KITTITAS COUNTY COMMUNITY DEVELOPMENT SERVICES

**RE: REVISED Transmittal of Comments – Elita Short Plat (SP-08-00041)**

TO: Community Development Services  
FROM: Christina Wollman, Planner II *CW*  
DATE: October 22, 2009  
SUBJECT: Elita Short Plat SP-08-00041

K.C.S.P. NO. 08-XX
PTN. SE 1/4 OF SEC. 9, TWN. 19N., RGE. 15E., W.M.
 Kittitas County, Washington

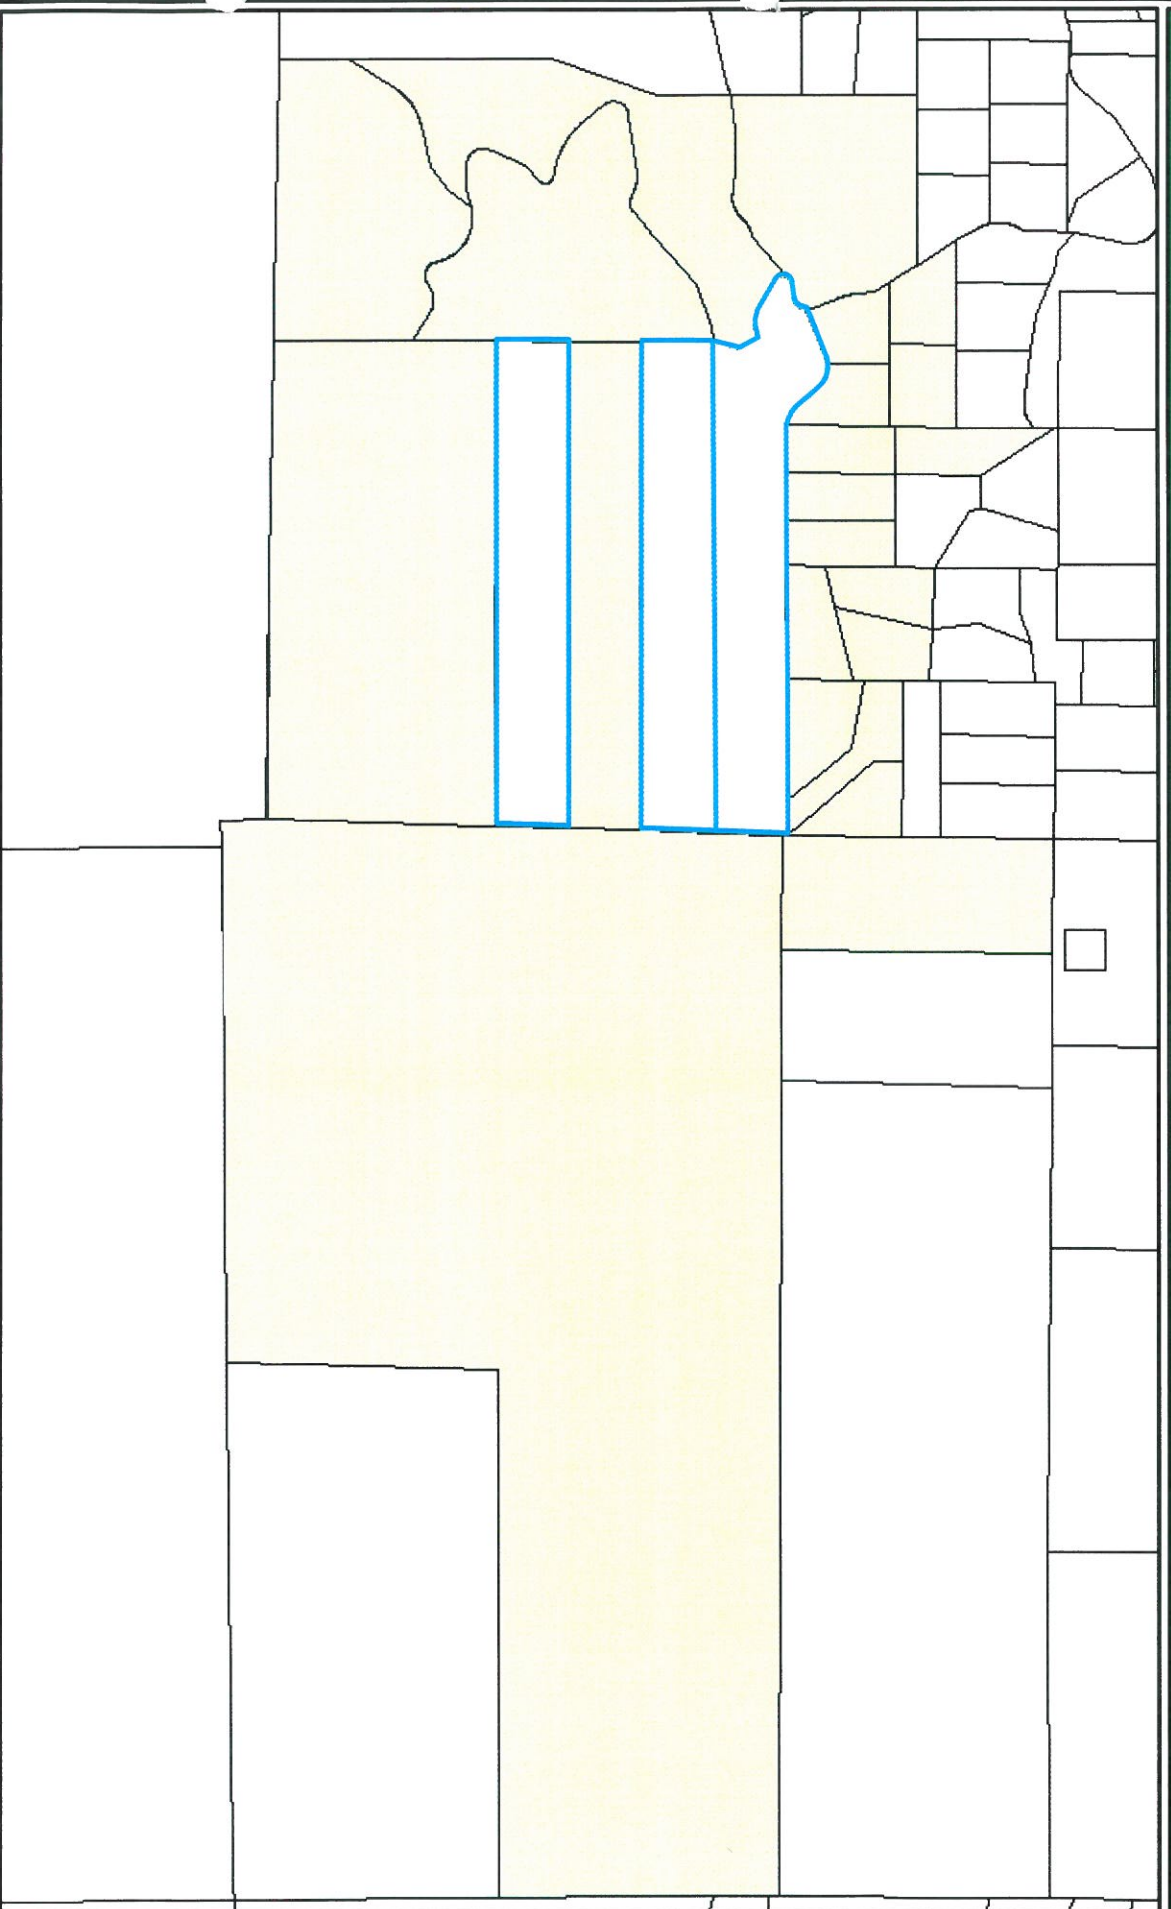
Second Access: A second access is required of this project. Prior to final approval, the applicant must submit a route that has easement or other access rights secured and recorded to Public Works for approval. The second access must conform to Kittitas County Road Standards and the second access requirements as clarified by the Board of County Commissioners on April 2, 2007. The BOCC clarified KCRS 12.01.095(2) with the following requirements: 1) If the second access is restricted to emergency access only, it must meet or exceed the following requirements: 60' easement, 20' roadway width, BST/ACP surface, and a paved apron. Access restrictions such as gates or bollards must be approved by the Fire Marshall; 2) If the second access is to be used for ingress and egress, it must meet the same standards of the first access.

Creek Crossing: Prior to crossing the creek, the applicant shall ensure all necessary provisions are taken and permits applied for. Crossing location shall be determined to be suitable prior to final approval.

3. Second Access: The second access route shall be shown on the final plat or within the vicinity map.
4. Improvements to South Cle Elum Ridge Road and Rocky Mountain Road: From Westside Road to the entrance to the Plat, access roads shall be constructed as High Density Roads that serve 40+ lots.

5. Cul-de-Sac: A cul-de-sac turn-around having an outside right-of-way or easement diameter of at least 110 feet shall be constructed at the end of Rocky Mountain Road. The driving surface shall be at least 96 feet in diameter. Cul-de-sacs must also conform to the requirements specified by the 2006 International Fire Code. Contact the Fire Marshal regarding any additional cul-de-sac requirements.

6. Joint-Use Driveway: A joint-use access shall serve no more than two tax parcels. See Kittitas County Road Standards, 9/6/05 edition.
  - a. Access easements shall be a minimum of 20' wide. The roadway width shall have a minimum width of 12'.

8. The following note shall be placed on the face of the plat, short plat, or other development authorization:

"Kittitas County will not accept private roads for maintenance as public streets or roads until such streets or roads are brought into conformance with current County Road Standards. This requirement will include the hard surface paving of any street or road surfaced originally with gravel."
